COMMUNITY SERVICES DEPARTMENT

August 10, 2018

Subject: 2018 Springs at Waterview Sketch Plan Amendment (SKP-18-002)

PLAN SHEET

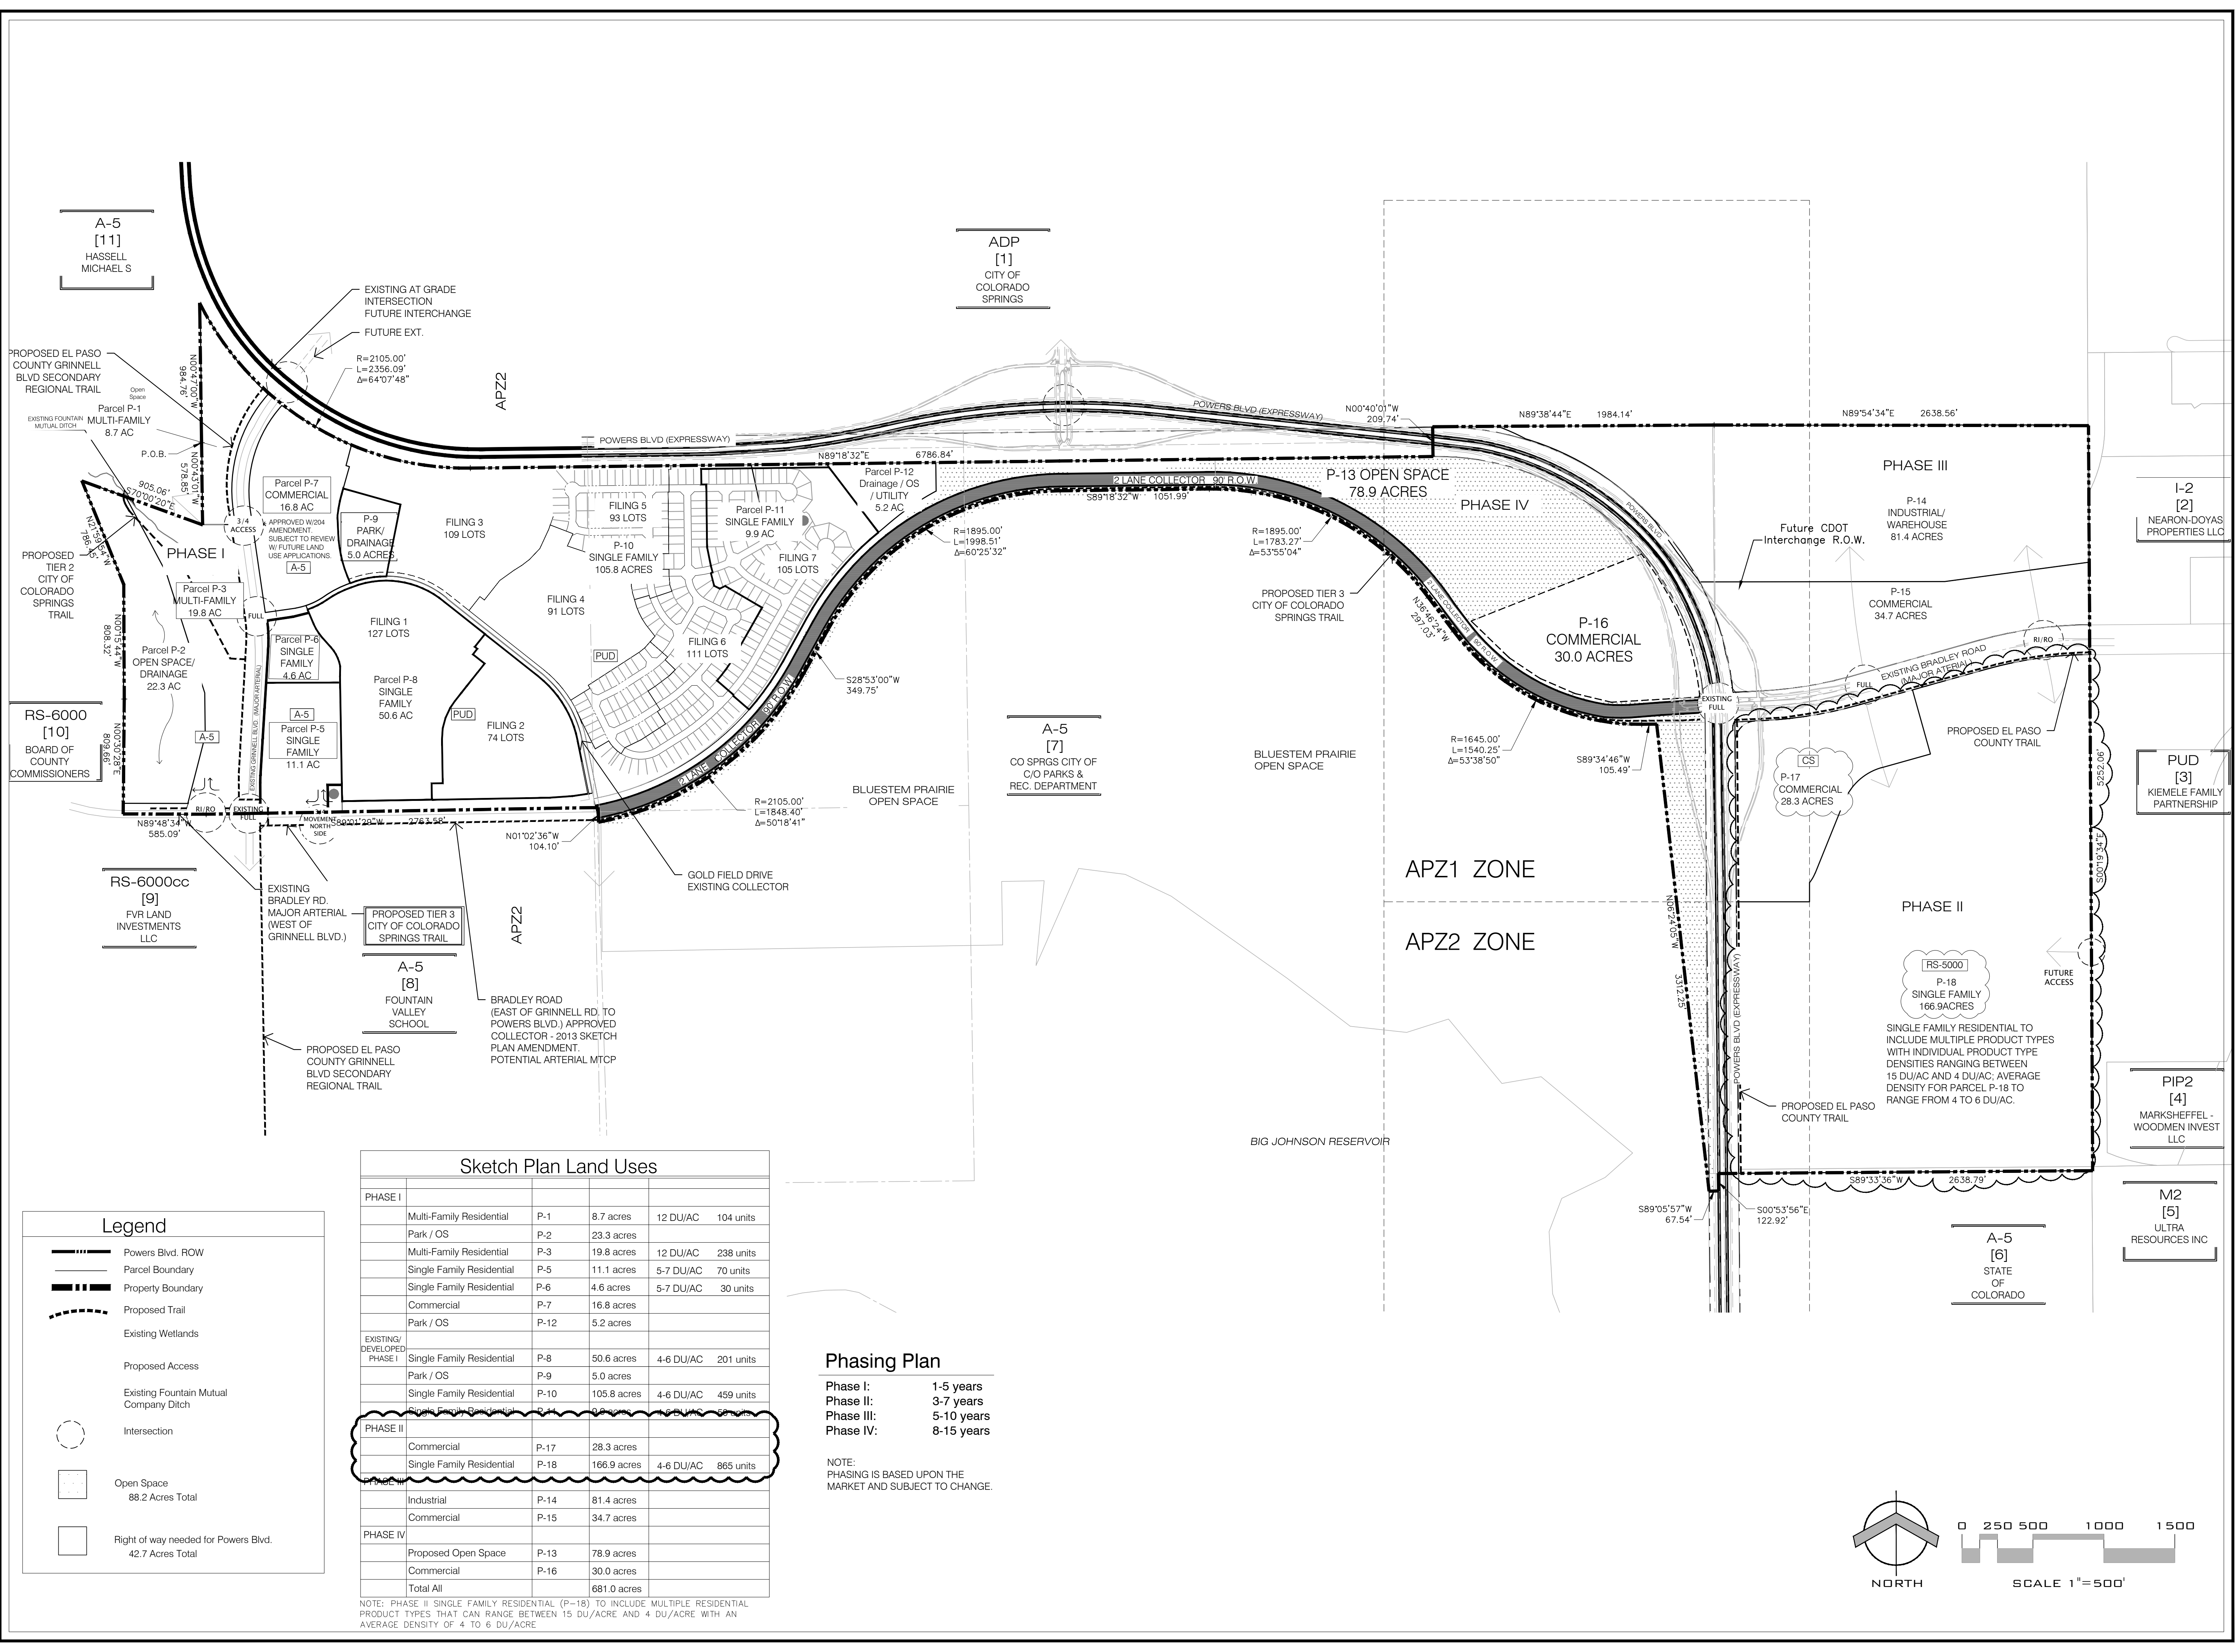
When the Springs at Waterview 2016 Sketch Plan Amendment was first reviewed in July 2017 and subsequently in October 2017, the plans showed the Grinnell Boulevard Secondary Regional Trail on the west side of Grinnell Boulevard, whereas it should have been shown on the east side. Furthermore, the 2016 Sketch Plan did not display the trail as it continues north of Bradley Road to Powers Boulevard, adjacent to the proposed subdivision.

Prior to the November 2017 Park Advisory Board meeting, staff met with the applicant, and a decision was made to show the Grinnell Boulevard Secondary Regional Trail on the east side of Grinnell Boulevard south of Bradley Road, and move it to the west side of Grinnell Boulevard, north of Bradley Road, where it will eventually intersect other proposed City of Colorado Springs and Fountain Mutual Metropolitan District trails. During this meeting, Parks staff notified the applicant that we would request a permanent trail easement on the west side of Grinnell Boulevard as a recommendation of the Springs at Waterview Preliminary Plan and Final Plat. At the November 2017 meeting, the Park Advisory Board endorsed the following recommendations:

“Recommend to the Planning Commission and the Board of County Commissioners that the approval of Springs at Waterview 2016 Sketch Plan Amendment includes the following conditions: (1) designate and provide to El Paso County a 25-foot trail easement along the west side of Grinnell Boulevard, north of Bradley Road, that allows for public access, as well as construction and maintenance by El Paso County of a primary regional trail, (2) the easement shall be shown on all forthcoming preliminary plans and final plats, and the aforementioned easement be dedicated to El Paso County on the

forthcoming final plat(s), (3) fees in lieu of land dedication for regional and urban park purposes will be required at time of the recording of the forthcoming final plats.”

Since the November 2017 Park Advisory Board endorsement, the applicant, Planning and Community Development staff, and Community Services staff had discussions regarding the aforementioned recommendations. As the relocated Grinnell Boulevard Secondary Regional Trail is no longer located within the bounds of the Springs at Waterview Final Plat, the applicant cannot show the trail or trail easement on the plat, nor can they dedicate the easement to El Paso County at the time of recording of the Final Plat. There are no legal mechanisms in place to allow for either of these actions, and the applicant or future land developer will dedicate the trail easement at such a time that the western side of Grinnell Boulevard is platted. As agreed upon in previous meetings and discussions, the 2018 Waterview Sketch Plan Amendment shows the trail along the west side of Grinnell Boulevard, north of Bradley Road to Powers Boulevard, and any future development in that area is tied to the guidelines of the amended Sketch Plan. As such, staff acknowledges the relocation of the Grinnell Boulevard Secondary Regional Trail to the west side of Grinnell Boulevard and appreciates the cooperation between the applicant and El Paso County.
